16 December 2013

**RE: MP 08-154 Minor Pipeline Corridor Realignments – Modification to the Gloucester Gas Project**

Tegan Harris  
Team Leader Development Assessment

# Tomago section

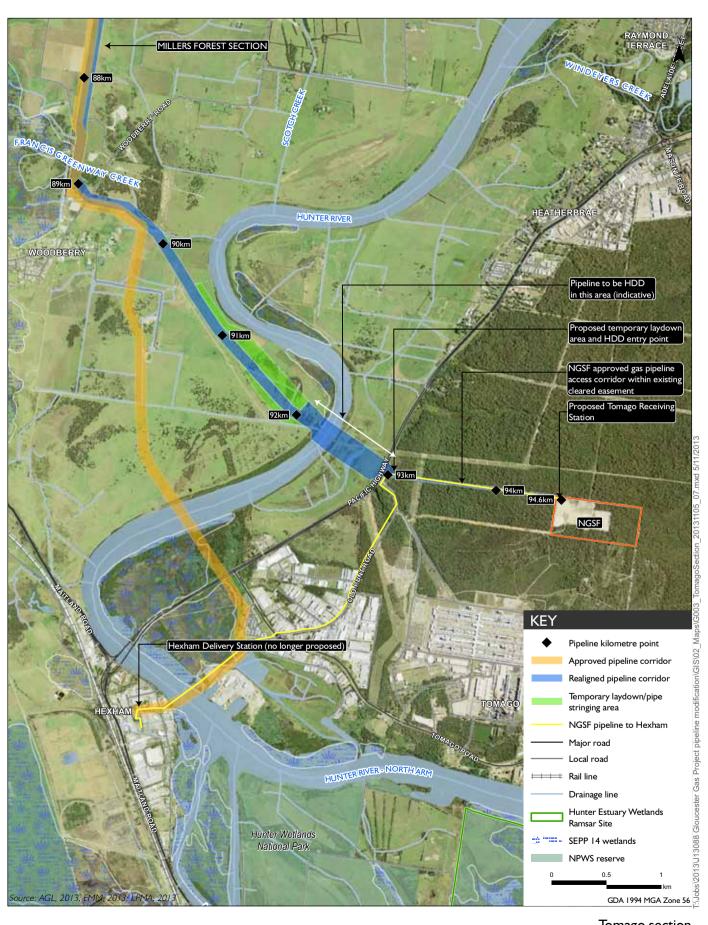
Council has reviewed the proposed modification and advise that the modification labelled 'Tomago Section' traverses land mapped as containing Swamp Oak Alluvial Forrest. It is requested that consideration be given to the potential impact of the proposal on this vegetation as part of the Department's assessment process.
